Arun Private Sector Housing response

**From:** Daniel Carpenter <Daniel.Carpenter@arun.gov.uk>  
**Sent:** 22 September 2025 12:01  
**To:** Planning.Responses <Planning.Responses@arun.gov.uk>  
**Subject:** Planning consultation on: FP/132/25/PL

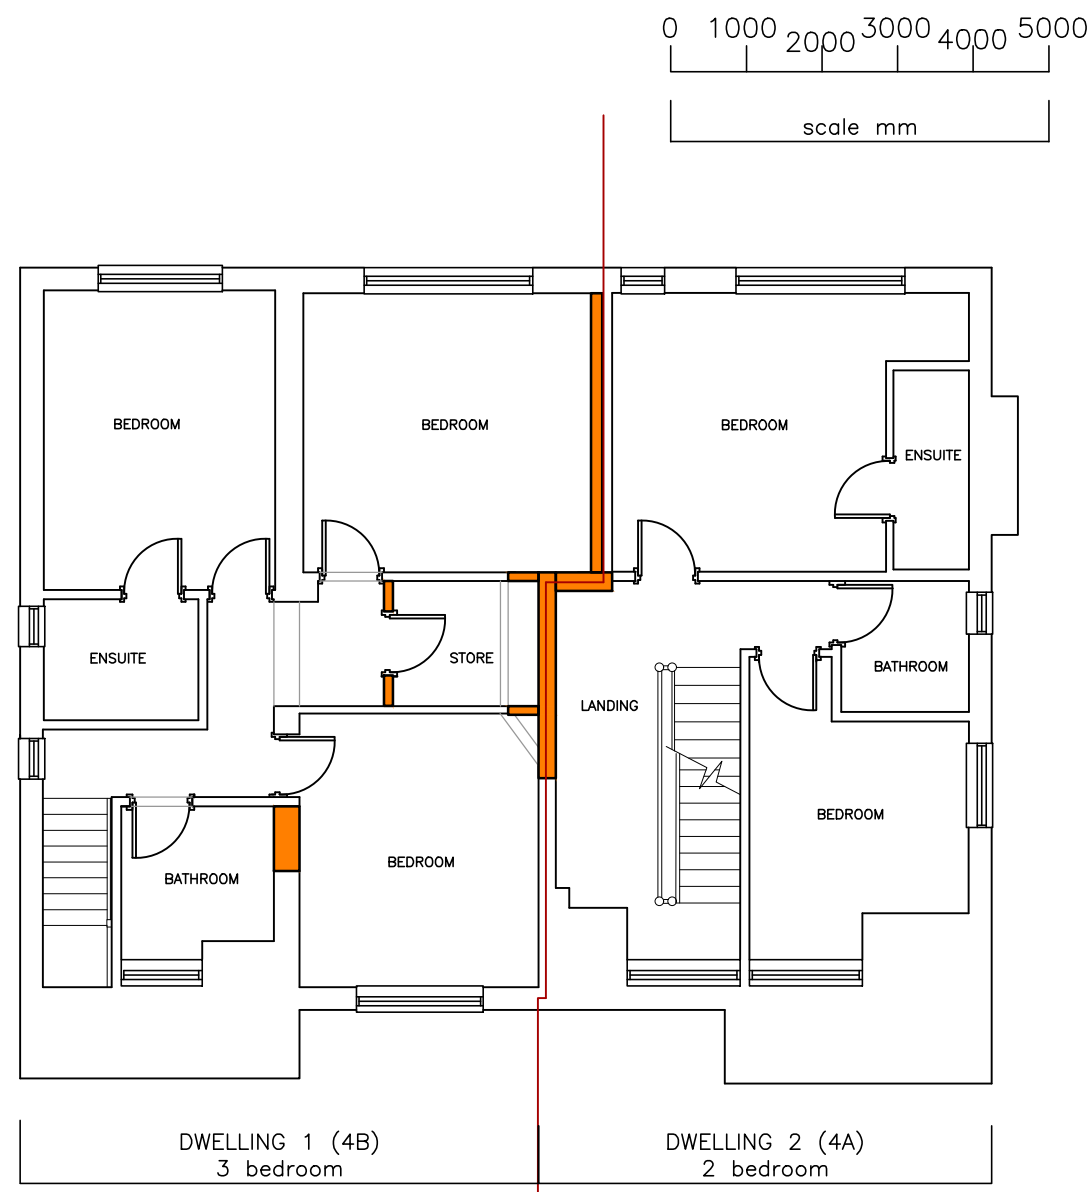
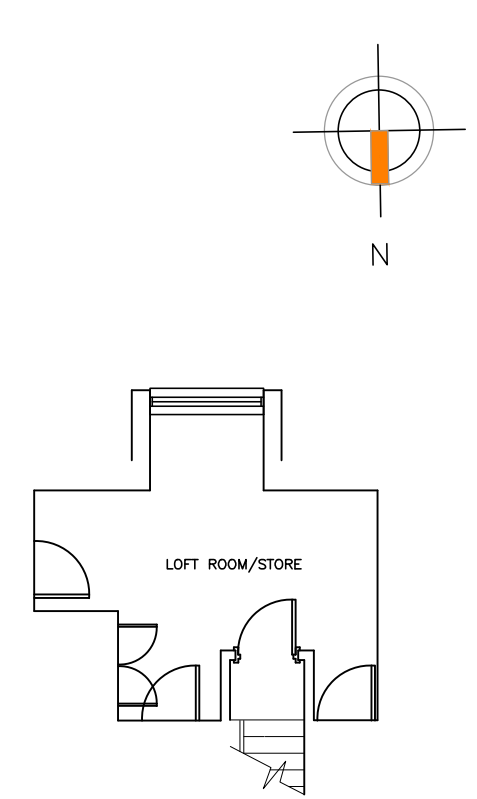
- 
- The internal escape routes which includes all floors and landings should provide 30 minutes fire resistance, including any service cupboards and understairs areas, and 30-minute fire resisting and self-closing fire doors (FD30S) with an overhead self-closing device, intumescent strip, and/or smoke seals, three hinges, and internal thumb turn latches must be fitted to each bedroom and kitchen. Doors to any service cupboards and understairs areas must also be 30-minute fire-resisting.

- Any hallways/landings/loft rooms (smoke, interlinked)
- Any kitchens (heat, interlinked)
- A Fire blanket should be provided in the kitchens
- Thumb turn latches must be fitted to the internal side of all final exit doors.

- Opening limiters should be installed to all windows above the ground floor to prevent windows being opened more than 100mm. Opening limiters should not be key operated
- The roof casements serving the loft storage room should be of an appropriate height and angle to provide a reasonable view outside of the immediate surroundings

- Kitchens and bathrooms/shower rooms/ensuites should have adequate mechanical extraction, regardless of any windows.
